# INDEPENDENCE PLACE AT CHEYENNE MOUNTAIN Fil. No. 1

## ADMINISTRATIVE SITE DEVELOPMENT PLAN

**SITE PLAN**  
**SDP2**  
 SHEET 2 OF 16  
 ALC PROJECT #19-020

SITE PLAN
SDP2
 SHEET 2 OF 16
 ALC PROJECT #19-020

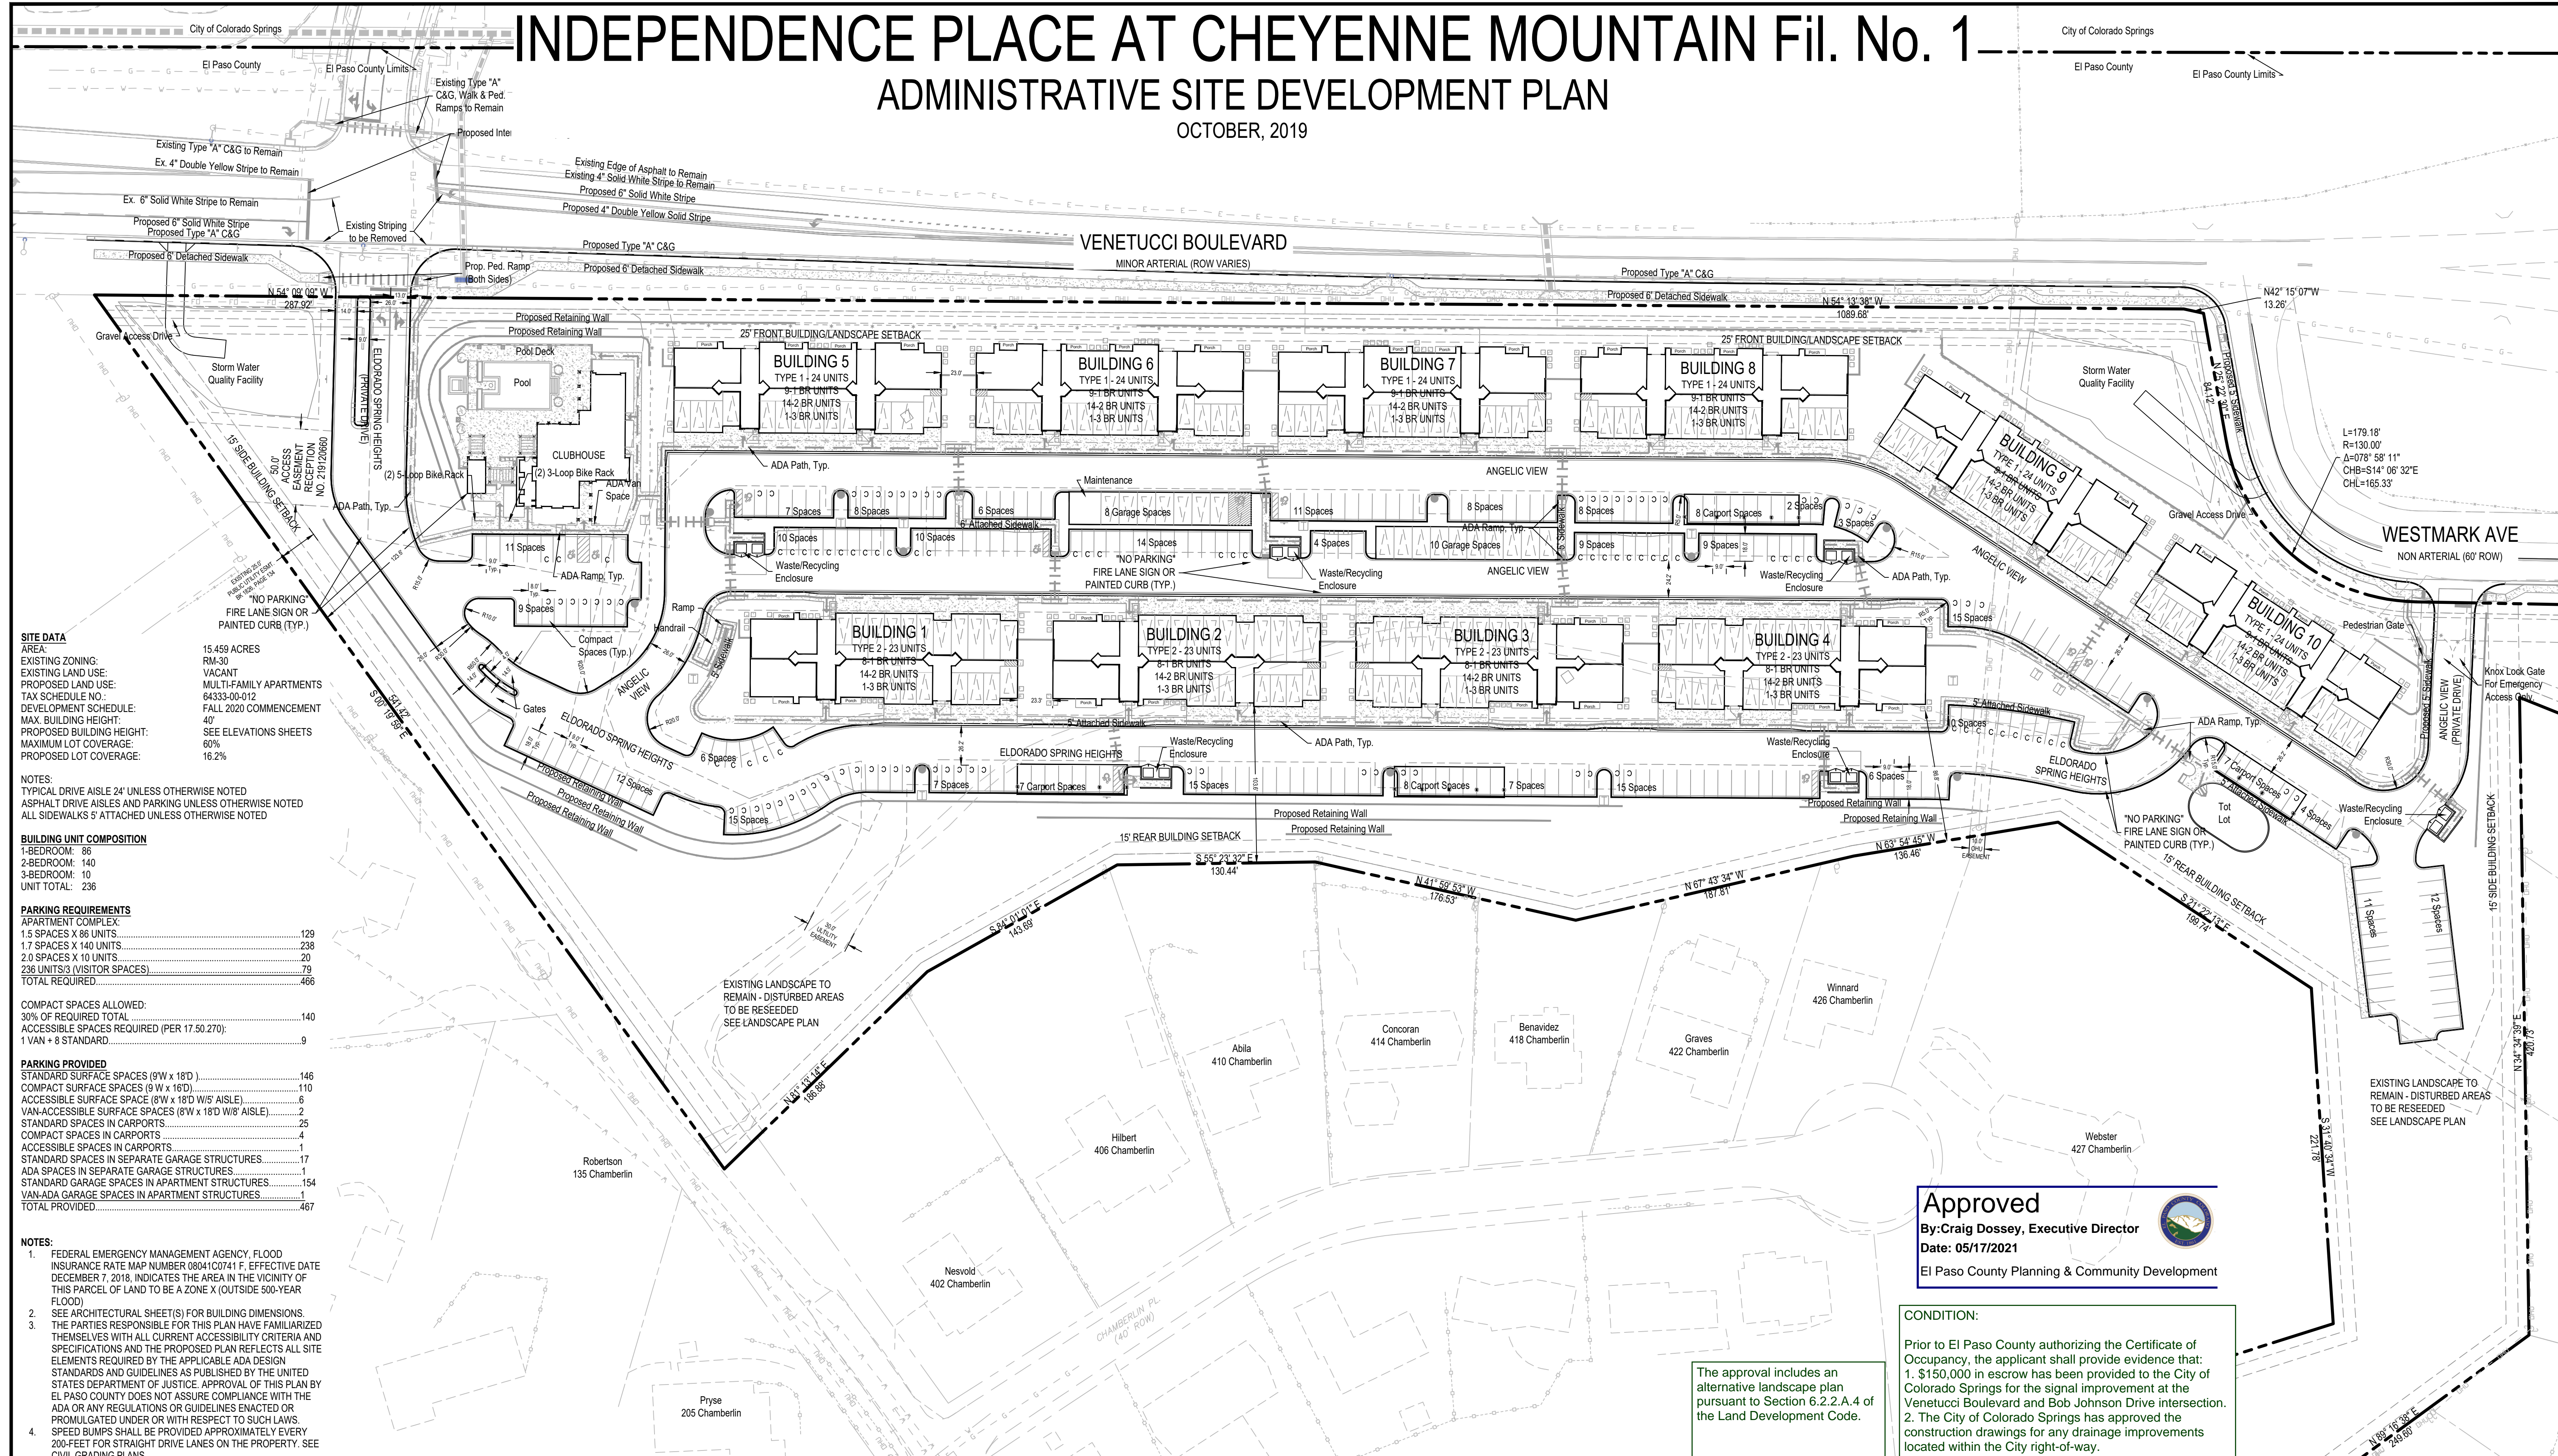
Not resolved:  
Section 6.2.5.F  
Bicycle  
Facilities. They  
are required  
per code, there  
seems to be  
adequate room  
near the  
clubhouse.  
Response: Bike  
Racks have been  
added south of  
the clubhouse.

Use effective date  
Dec. 7, 2018.

Note updated  
accordingly.
